29 January 2015

**Re: DFS Galleria Refurbishment (SSD 6715) Notice of Exhibition**

**Dr. Deborah Dearing**  
Executive Director, Place Renewal  
Sydney Harbour Foreshore Authority

01 **GROUND LEVEL PLAN**
Scale: 1:100

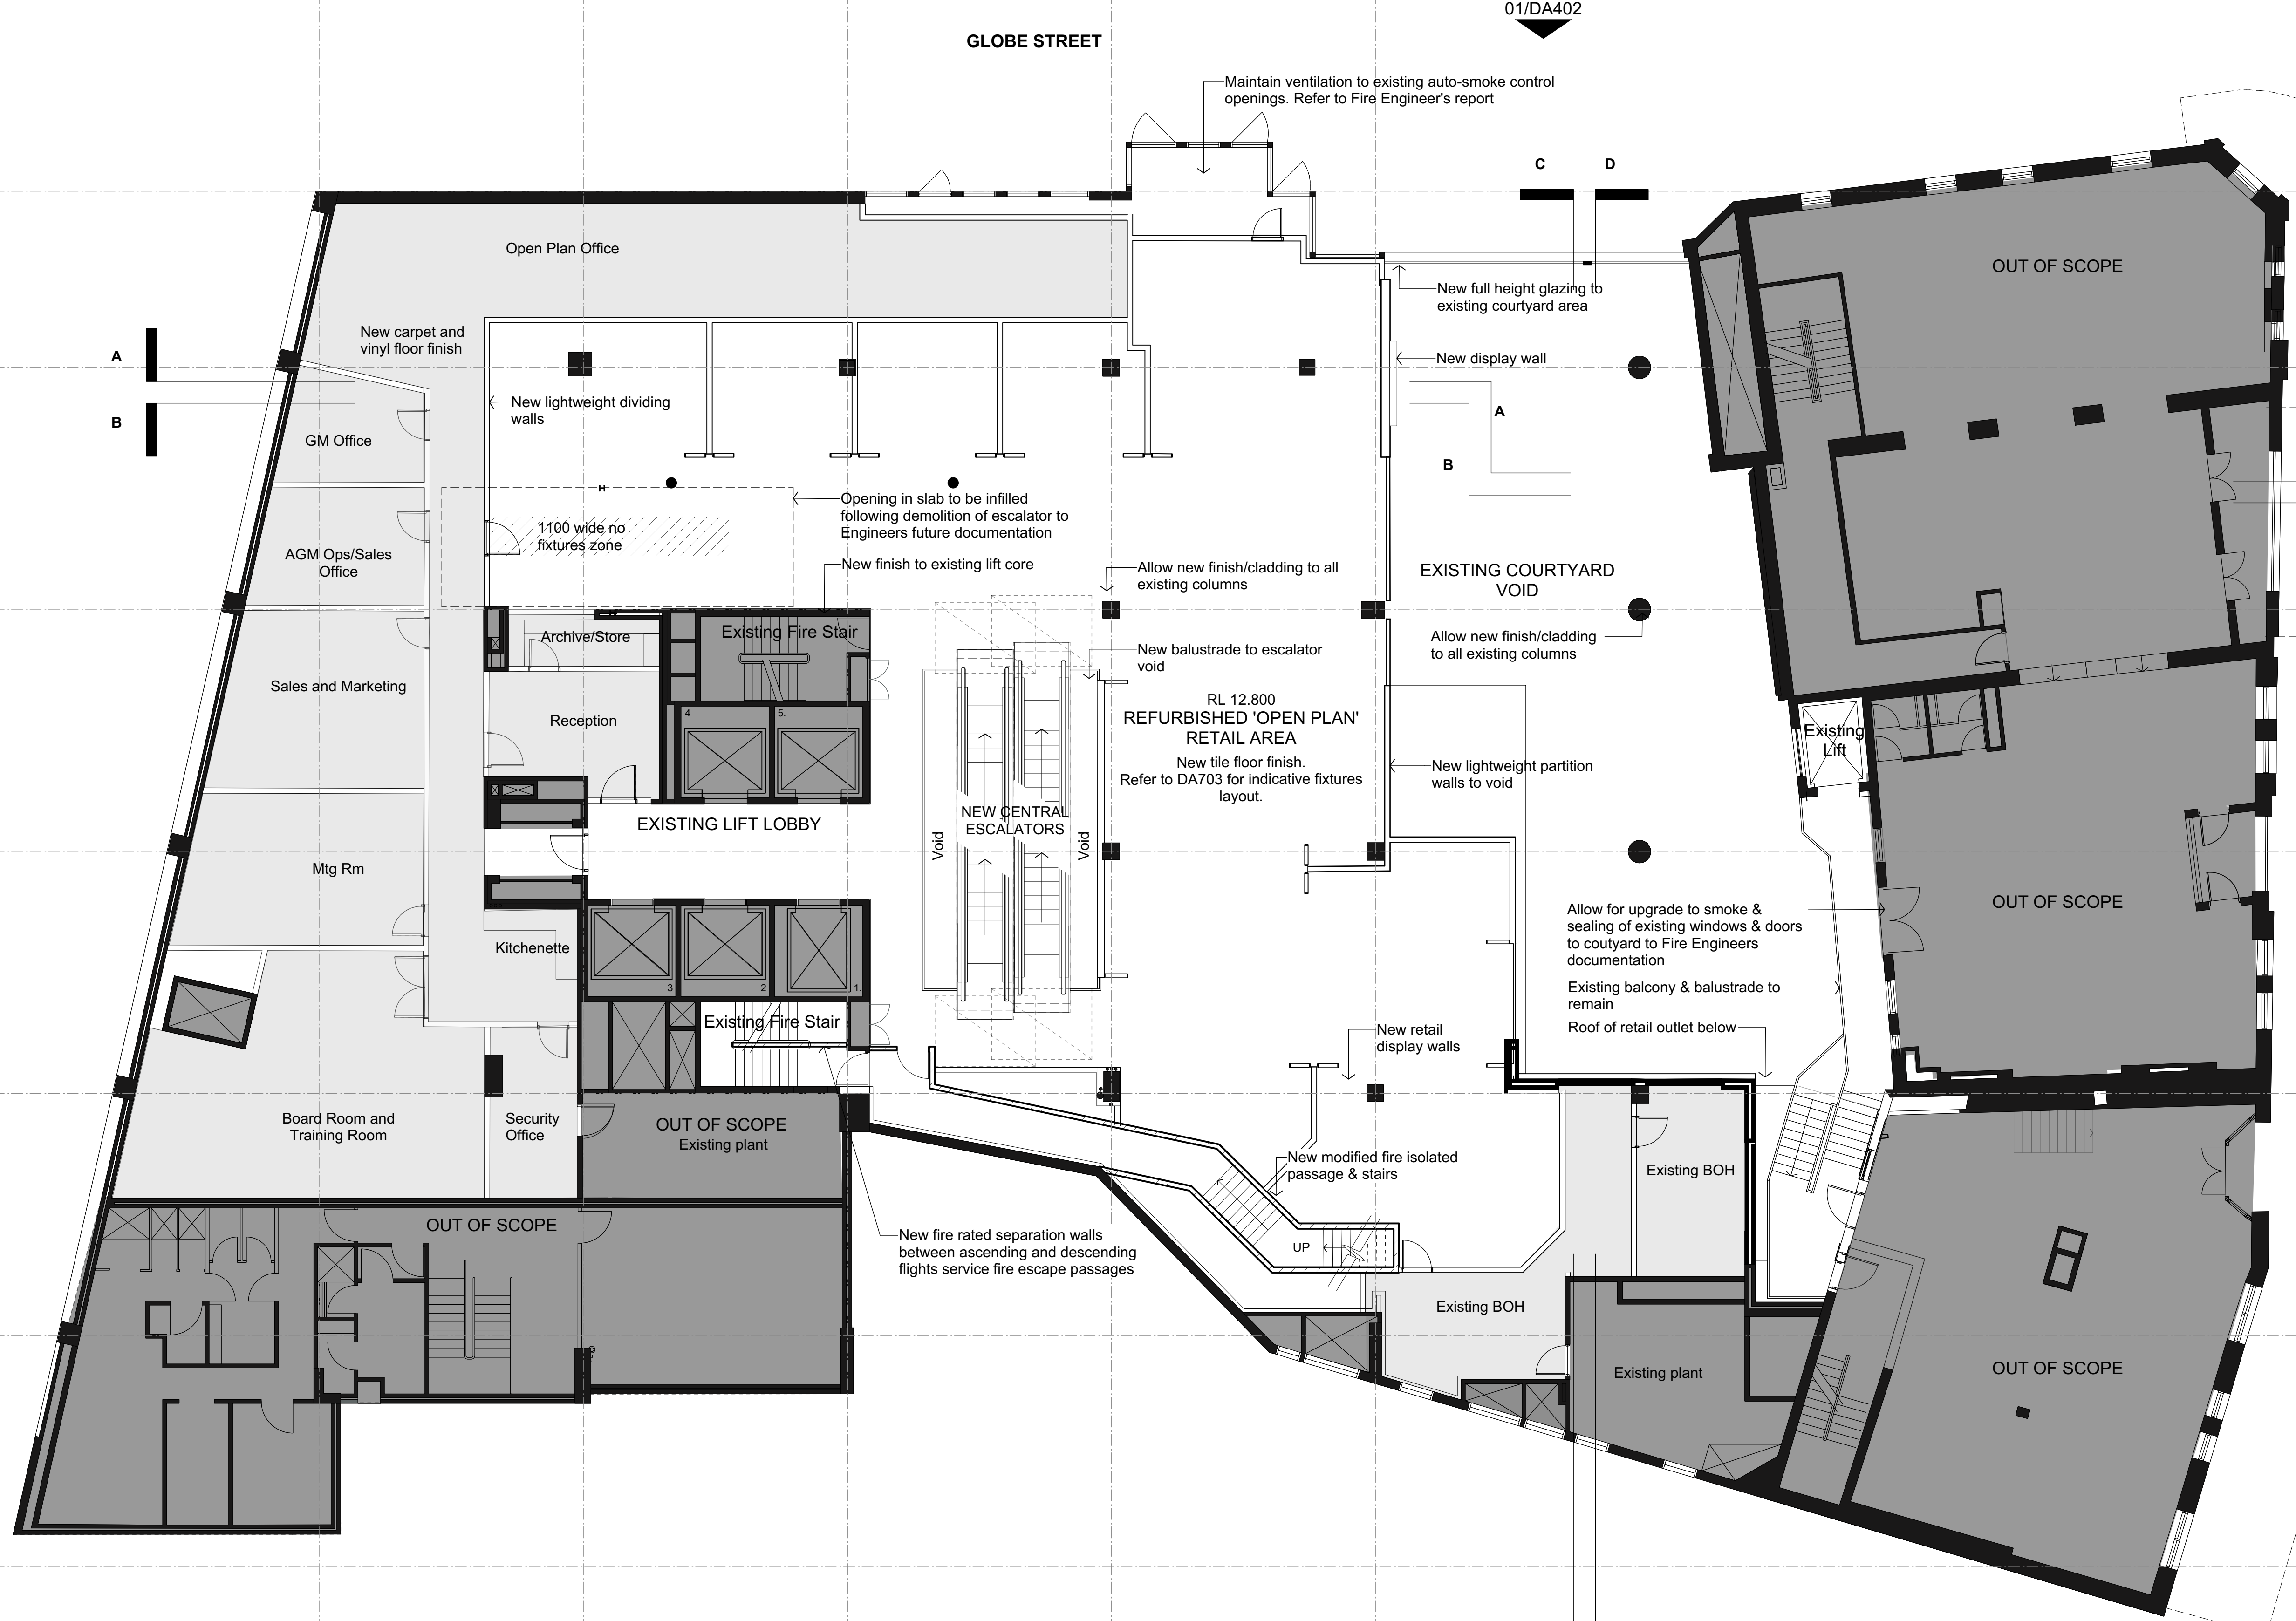
For this application, artist's impressions have been submitted showing a concept for the interior fit-out. A black and white patterned tile floor finish is proposed throughout the ground floor and across the entry alcove from George Street. The style of the patterned tile floor across the entry alcove does not provide an appropriate transition between the public domain and the shopping centre. The George Street entry should be finished with a consistent black tile with a matte finish (or similar) to relate to the proposed tile pattern within the shopping centre and also to relate to the existing footpath surface and any future paving of the footpath (i.e., bluestone or granite paving). Accordingly, a design condition of consent is requested to reflect this recommendation.
